Application No: AB/49/22/HH
Site Address: 31 Tarrant Wharf Arundel BN18 9NY
Description of works: Erection of single storey rear extension including the installation 2 x rear balconies and side rooflight and alterations to fenestration. This application may affect the character and appearance of the Arundel Conservation Area.

Thank you for your internet representation made on 26th May 2022 which has been recorded as an objection with the comments as follows:

DRAWING TITLE
 PROPOSED FLOOR PLANS,
 SECTION AND ELEVATIONS

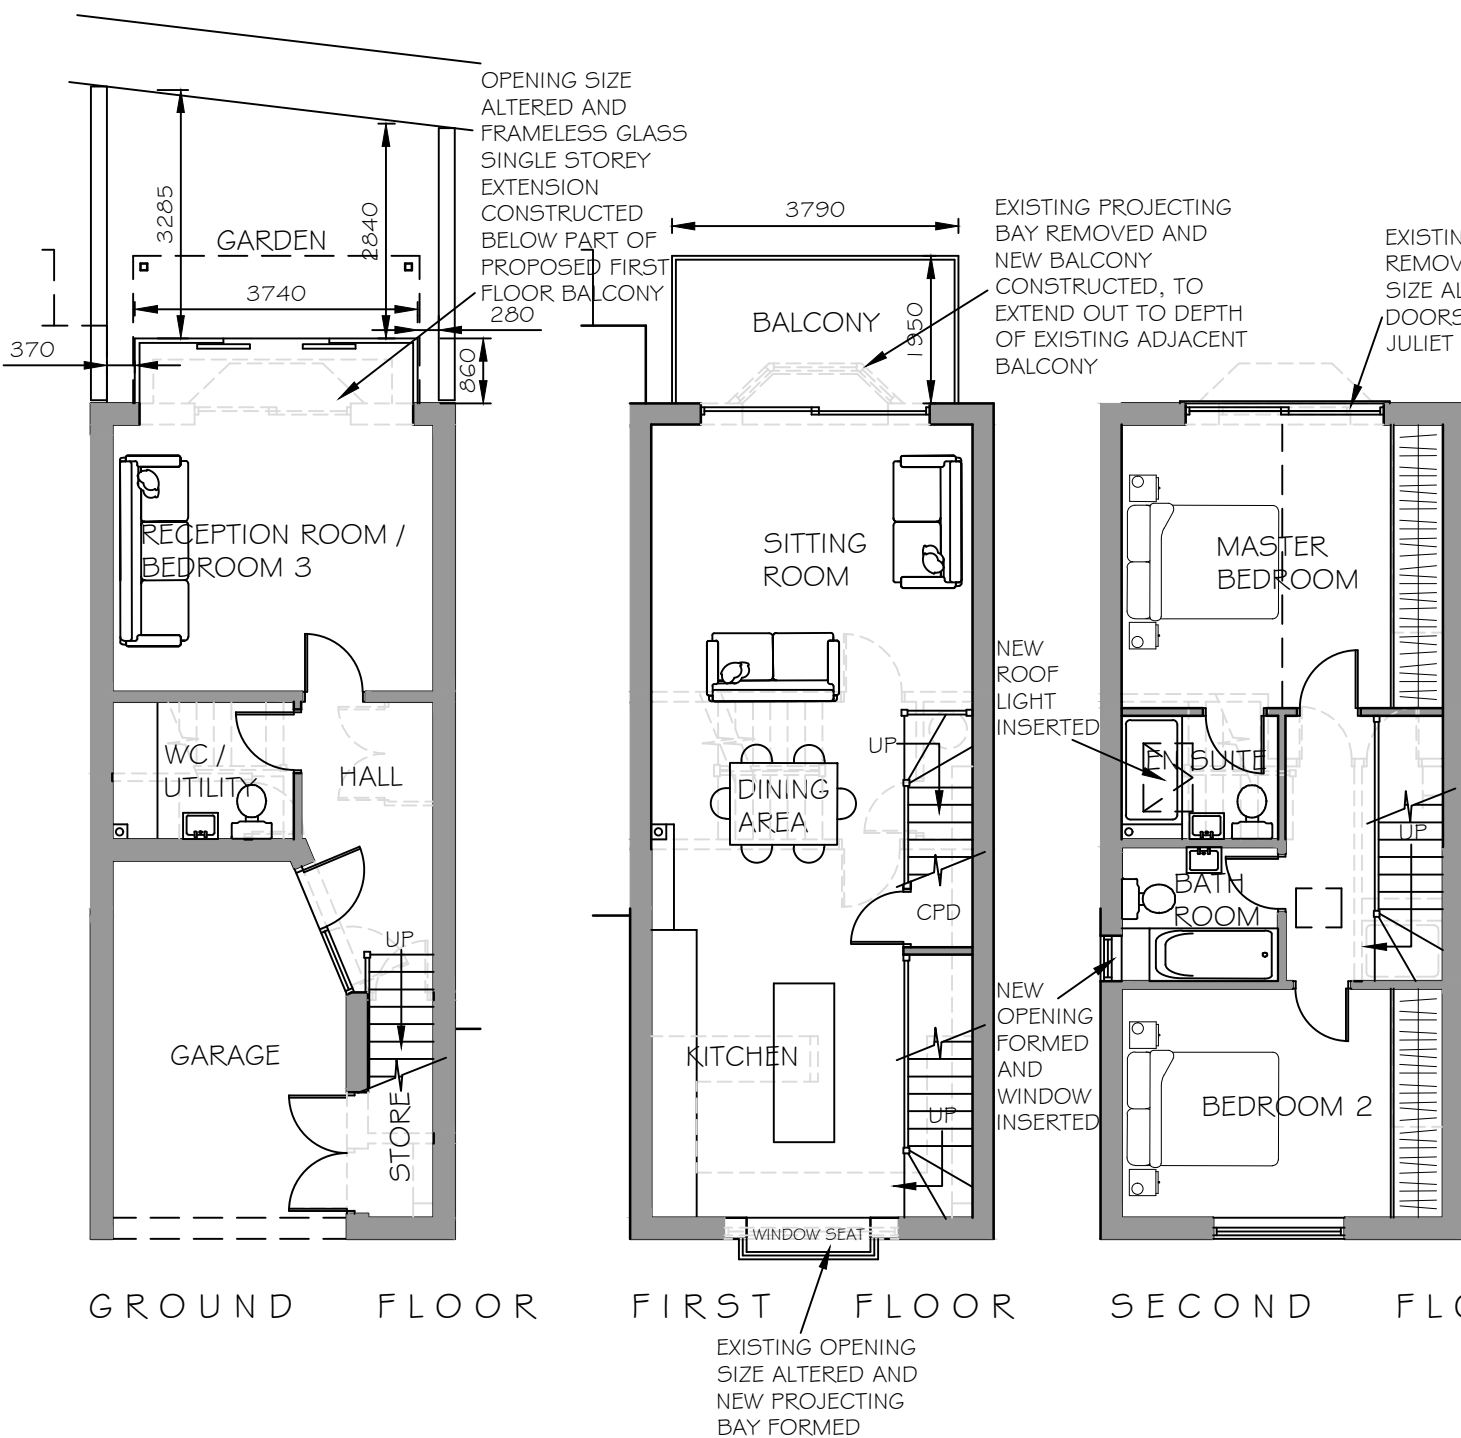
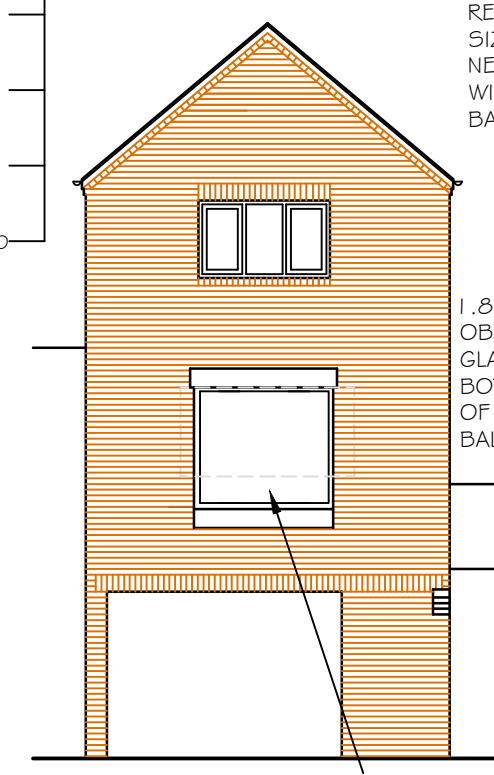
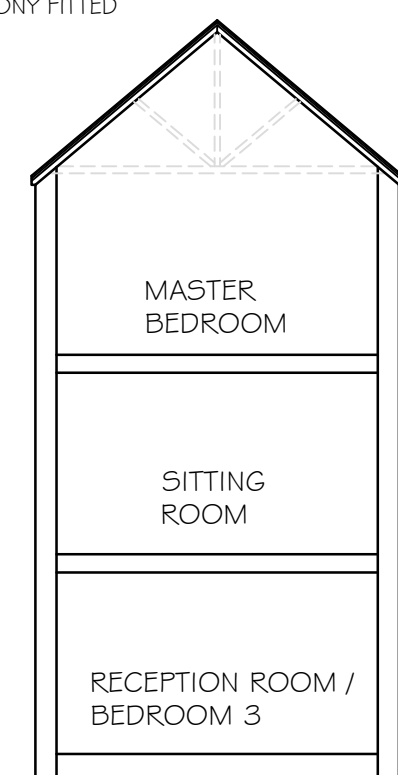
None of the proposed changes to the riverside (rear) of the property on the ground, 1st and 2nd floors are in keeping with the style of the Tarrant Wharf development as a whole.

The rear of the 15 houses in Tarrant Wharf, which is itself in the Arundel Conservation Area, which face the river make up a consistent frontage which would be spoilt by the development.

The additional glass would be a dominating and unwelcome feature which would be at odds with the existing pattern of the other Tarrant Wharf houses, and the changes should be resisted.

In particular, the proposed 1st floor balcony is too large and ugly and would be totally out of character with the neighbouring balconies, and the proposal to fit opaque glass sides is especially out of character.

The proposed replacement of the 2nd floor window is also out of character, in terms of size and style, and will spoil the consistent pattern of the Tarrant Wharf development.
